Submission for Job: #6010 SSD 6010 - One Residential Building (Student Accommodation) within Darling Drive Plot

**SSD 6010 - One Residential Building (Student Accommodation) within Darling Drive Plot**

**30 July 2013**

SICEEP - SSDA3 Shadow Study

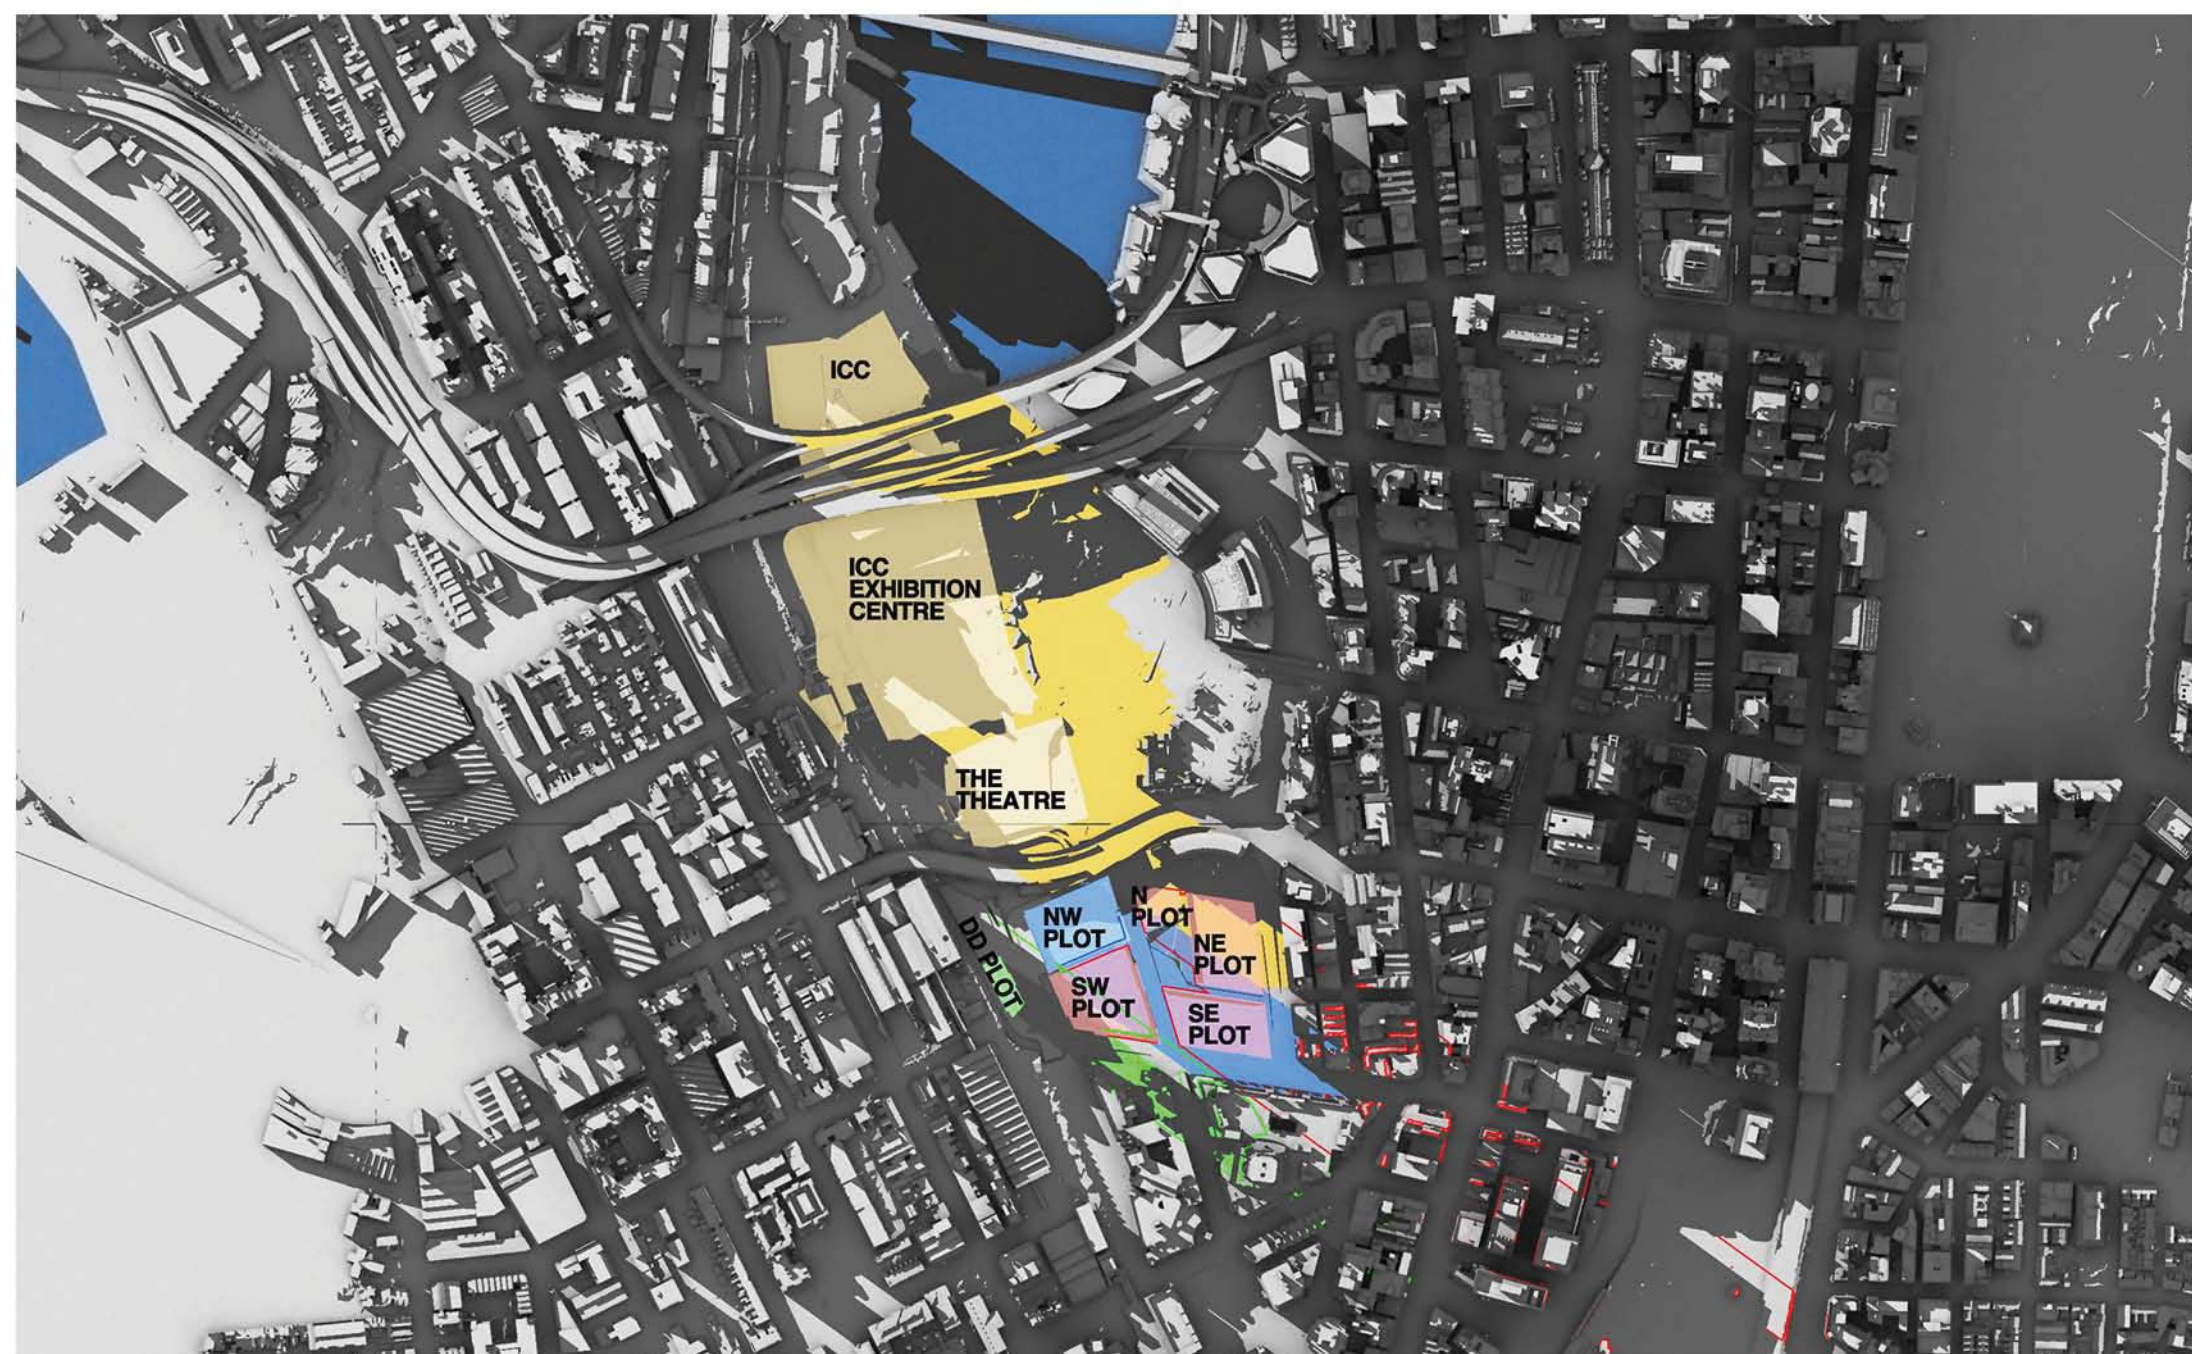
At 9am, 10am and 11am the west façade is totally in shadow due to other parts of The Peak building itself.

At 12pm there is still substantial existing shadowing on the west façade caused by the irregular shape of the west facade.

At 1pm the existing shadowing has been substantially removed, but not totally removed.

By 2pm the existing shadowing has been totally removed, but that is too late to achieve two hours of direct sunlight before 3pm.

SHADOW DIAGRAMS: PERSPECTIVE, SHOWING THE PEAK, WINTER SOLSTICE

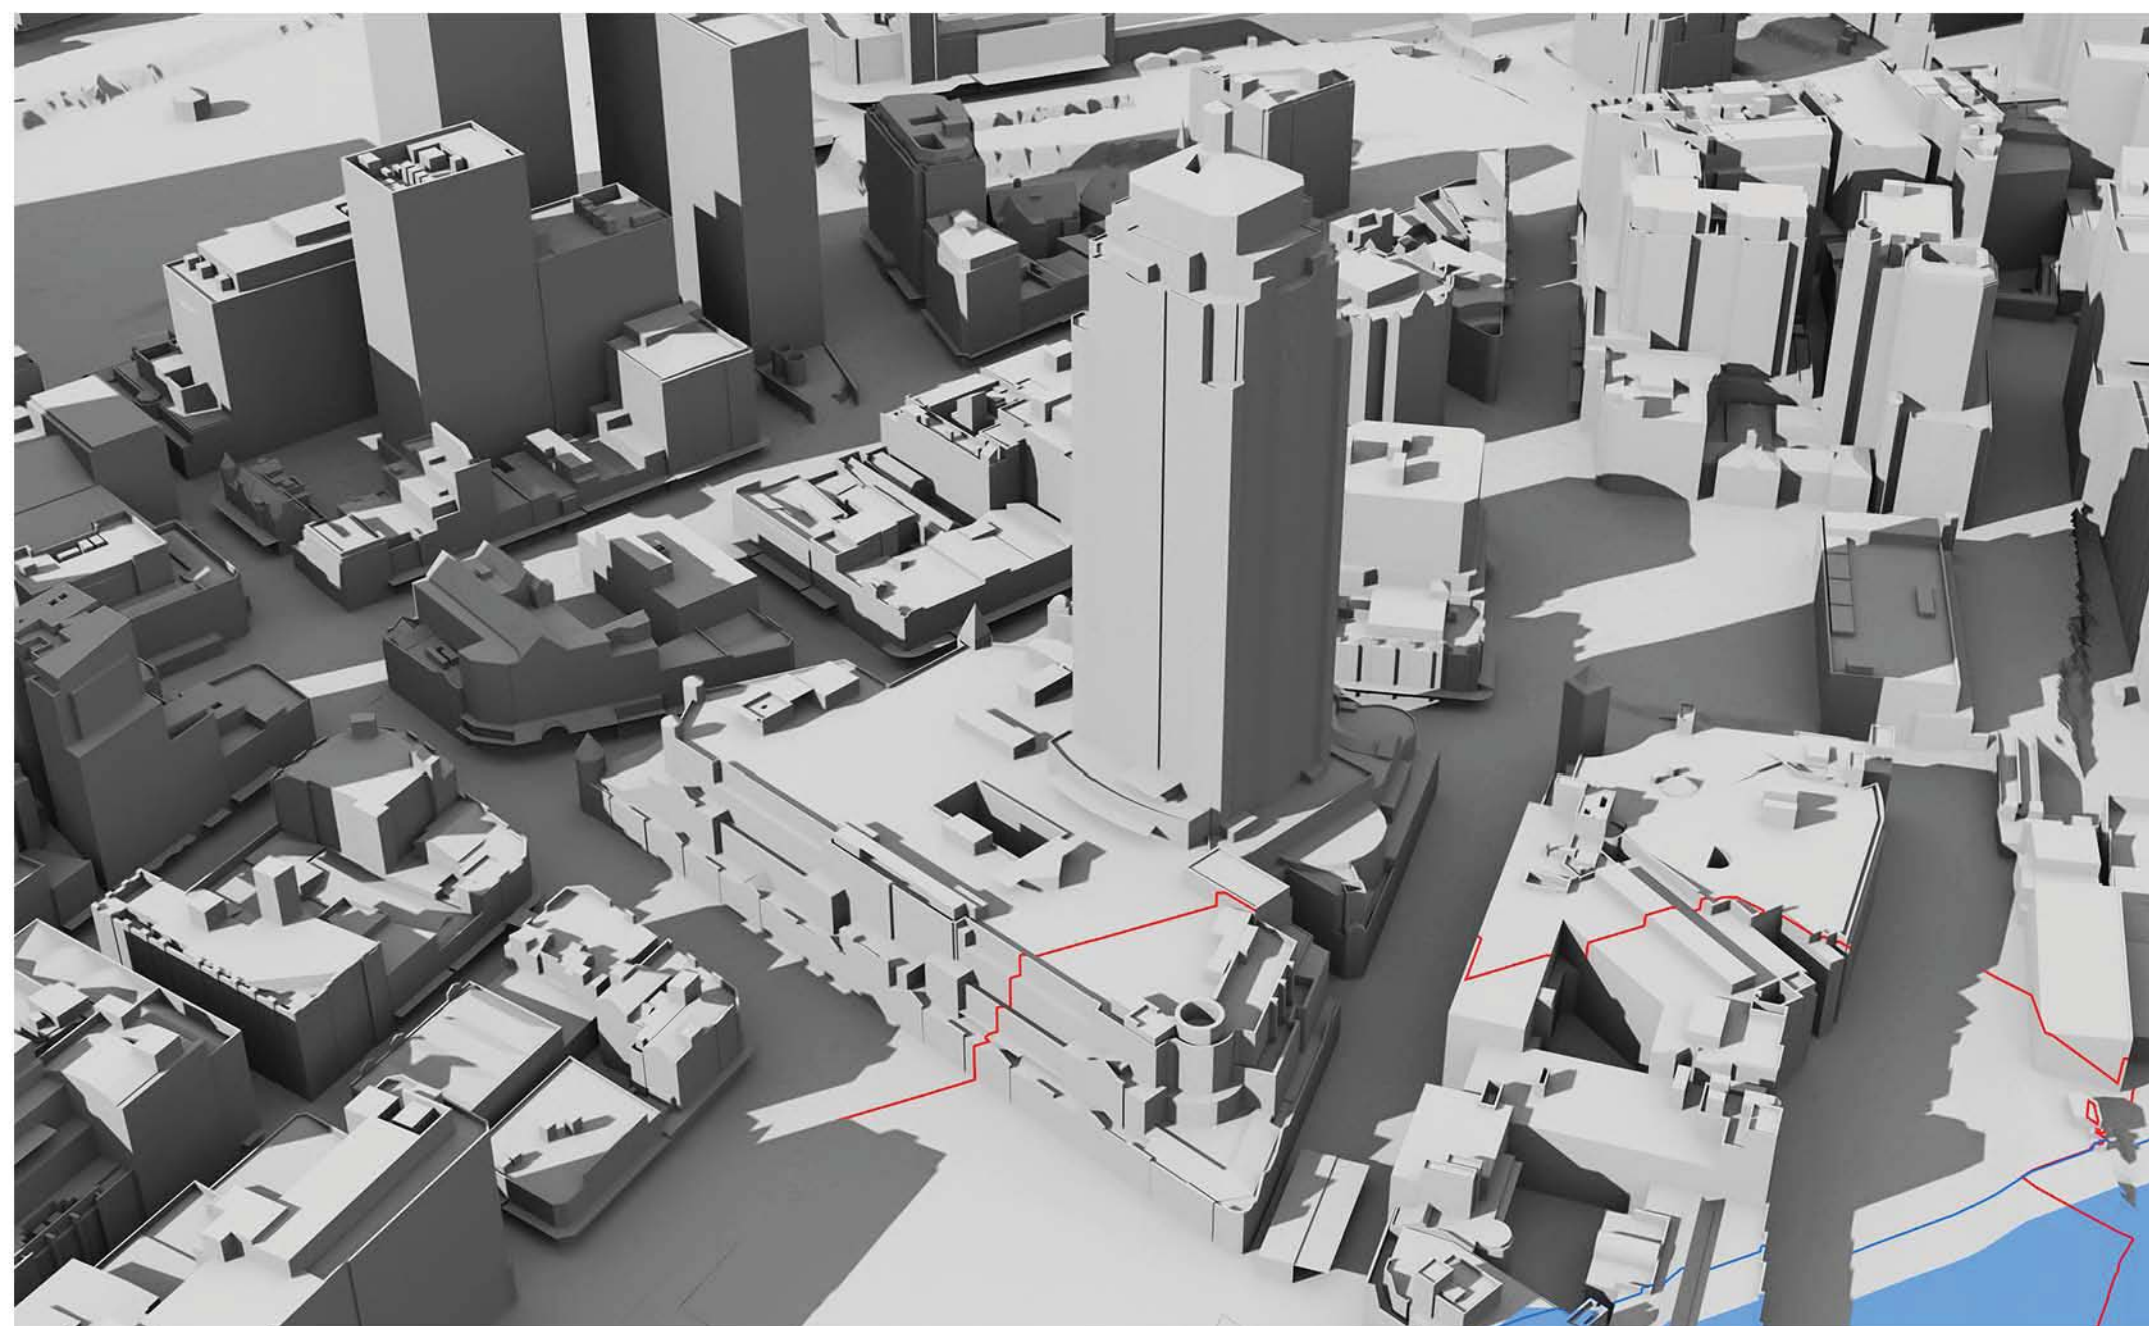
At 9am, 10am and 11am the west façade is totally in shadow due to other parts of The Peak building itself.

At 12pm there is still substantial existing shadowing on the west façade caused by the irregular shape of the west facade.

At 1pm the existing shadowing has been substantially, although not entirely, removed. However, overshadowing of lower levels of the west façade by the concept proposal parameter plan shadows for the N,NE and SE plots has already started.

By 2pm the existing shadowing has been totally removed. However, overshadowing of the west façade by the SSDA4 and SSDA5 buildings has appeared and risen further up the west façade than the concept proposal parameter plan shadows for the N,NE and SE plots, which is still present.

It can be concluded that, as a result of combination of the proposed development with existing shadowing of the west façade, some single aspect apartments on the west façade and the south-west dual aspect corner apartments which currently receive less than 2 hours direct sunlight to habitable rooms and 50% of the private open space between 9am and 3pm on 21 June will suffer additional overshadowing. It is beyond our skills to count the number of such apartments. We note that the proponent has made no attempt to do so.
